Application by Highways England for an Order Granting Development Consent for the A38 Derby Junctions Scheme
Table for Examining Authority's Rule 17 request for further information regarding draft Development Consent Order Schedules 5 and 7

Issued on 12 November 2019

The following table sets out the Examining Authority's request for further information regarding draft Development Consent Order Schedules 5 and 7.

Drawing Title
**LAND PLANS
REGULATION 5(2)(i)
SHEET 1 OF 10**

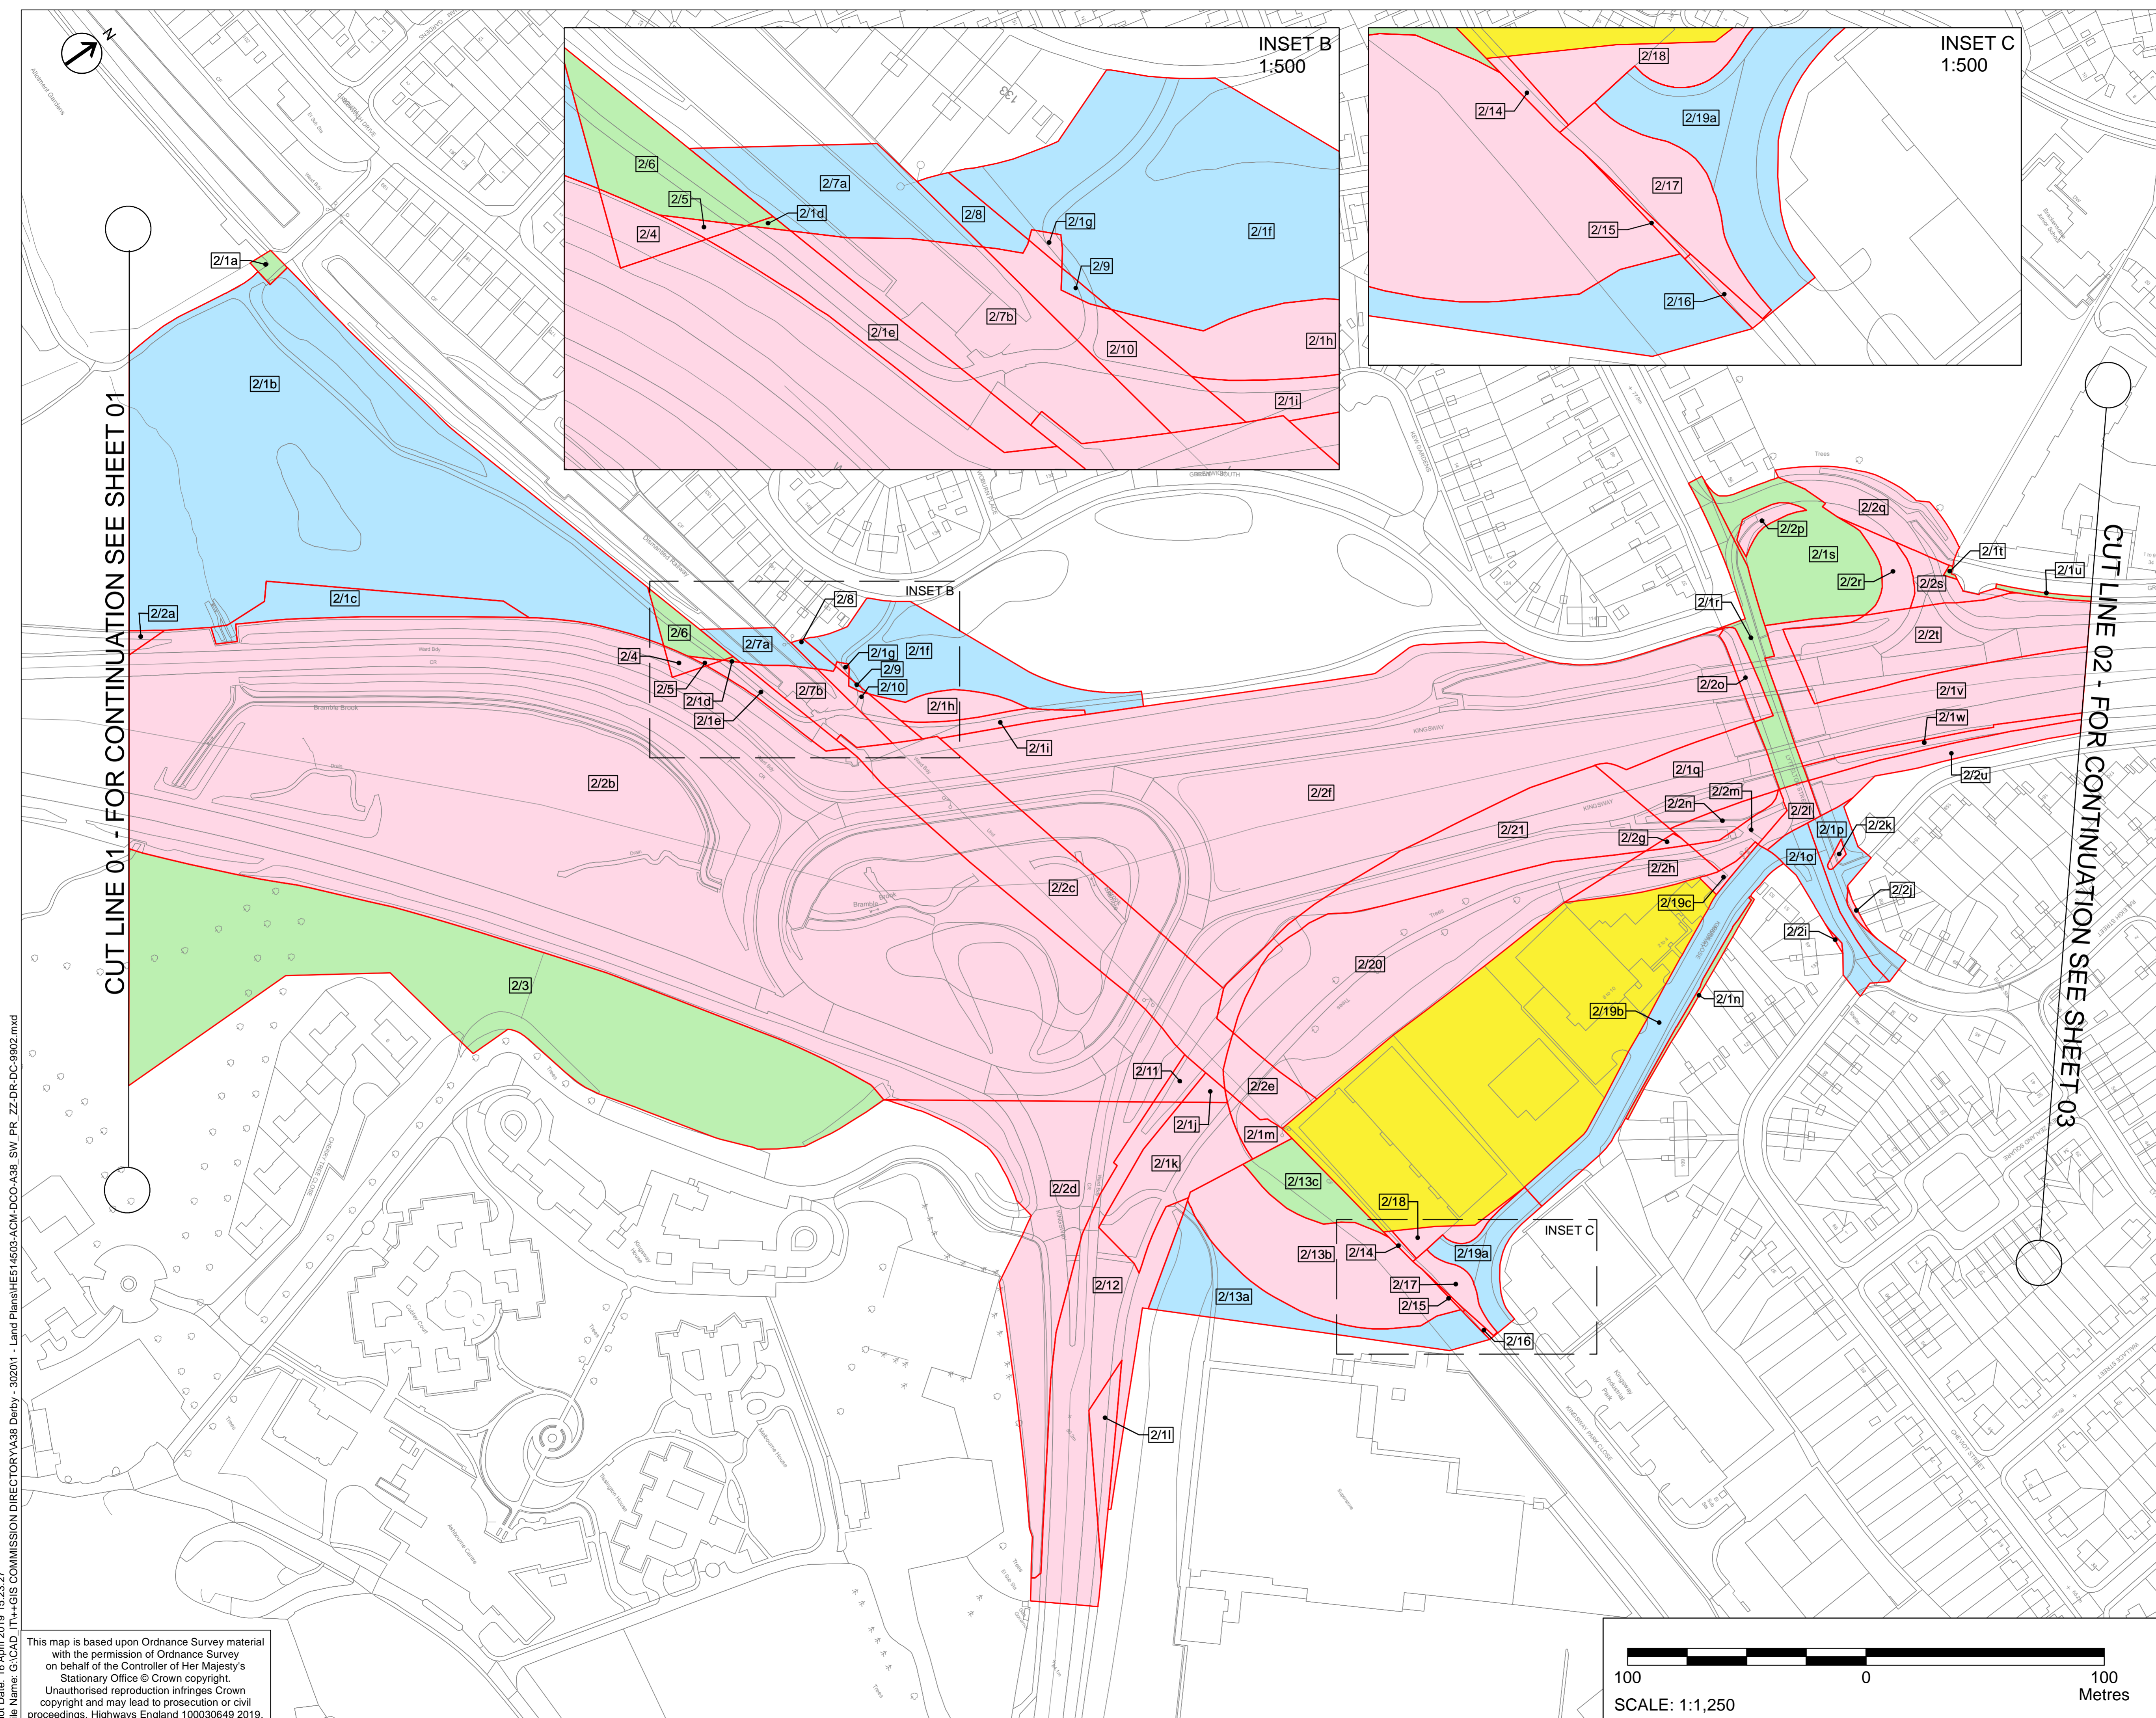
13.	2/1a, 2/1b	Remove plot reference 2/1b, consistent with the BoR, SoR and Land Plans?
14.	2/1d	The purpose given is not consistent with the SoR. Should dDCO Schedule 7 and/or the SoR be amended?

15.	2/1l	Should the plot reference be amended to 2/1n, as the SoR and Land Plans? The purpose given is not consistent with the dDCO Schedule 1 description of Work No. 3, as referenced by the SoR. Should dDCO Schedules 1, 7 and/or the SoR be amended?

16.	2/1r	Should the Land Plans be updated to clarify plot references above and below the Brackensdale underbridge?
17.	2/6	Should Work No. 8 be included, as the SoR, and the purpose updated accordingly? Should the purpose include for the <u>maintenance</u> of the cycle track? If so, is it necessary for this plot be moved to Schedule 5?
